From: Sue Howell
Sent: 20 October 2016 16:33
To: Planning.Responses
Cc: David Innes
Subject: FW: Planning Consultation on: BN/43/16/PL

REVISED Comments from Greenspace 20/10/2016

Site Address: Angels Nursery Yapton Road Barnham PO22
0AY

Description of Works: 95 No. dwellings together with access,
landscaping open space & associated works.

Fig 2: Proposed layout

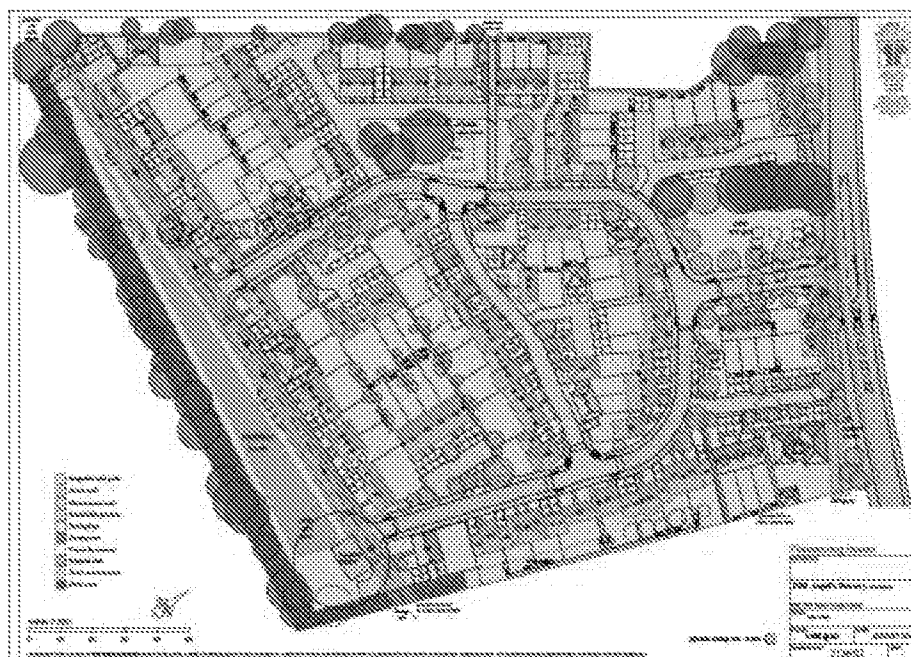
Developments of 10-200 dwellings or more are expected to provide open space on site. The Council's SPG guidelines which apply to developments of houses and are based broadly upon the National Playing Fields Association's (NPFA) "Six Acre Standard". Under superseded Fields in Trust guidelines (FIT) this requires that 3.2 hectares of open space are provided for every 1,000 people ie 32 square metres of open space per person. We would require confirmation of the areas of public open space being proposed with this development. As there are 95 dwellings proposed for this site, then provision of LAP and LEAP would be sought on site with the addition of Multi-Use Games Area (MUGA) contribution being sought. The present details indicate an on-site open space provision of 4652m², however 2289m² of this is indicated as retention basin and would not be suitable as open space. The open space indicated at present does not meet the minimum requirements.

Forming part of the application and prior to any consent being given a full landscape scheme should be submitted for approval, detailing species choice, position, densities and size at time of planting. This should be plotted in plan and list form and in relation to the trees and vegetation to be retained in the locale, so that a clear picture of the proposals can be seen. These details are required to assure the adjacent land setting is maintained, the setting is uncompromised and the proposals are appropriate to its setting. The retained vegetative areas to the periphery of the site would create wildlife corridors and for the retention of valuable established vegetation.

Any trees or vegetation that fall within the proposed or periphery of the development, may provide significant aesthetic impact to the location. Any trees in particular along the boundaries, which adjoin neighbouring land, in particular is the vegetation cover to be seen to all boundaries particularly to the east, south and west of this site. The trees that adjoin the caravan park potentially provide valuable screening and should be retained. Trees are present within the site and to an area on the northern entrance area and some consideration has been given to these in relation to the areas of proposed open space within the proposals. Any considered tree removal from this site should be agreed with Arun District Councils Tree Officer. Root protection Areas (RPA) should extend into the development site and to those in neighbouring land. Before construction, a tree protection scheme must be in place for any retained trees including trees whose root protection areas fall within the construction zone from neighbouring land. This should

be in accordance with BS 5837:2012 'Trees in relation to construction' Any removed trees should be mitigated for allowing for inclusion of native species for biodiversity purposes and fitting to the semi-rural setting.
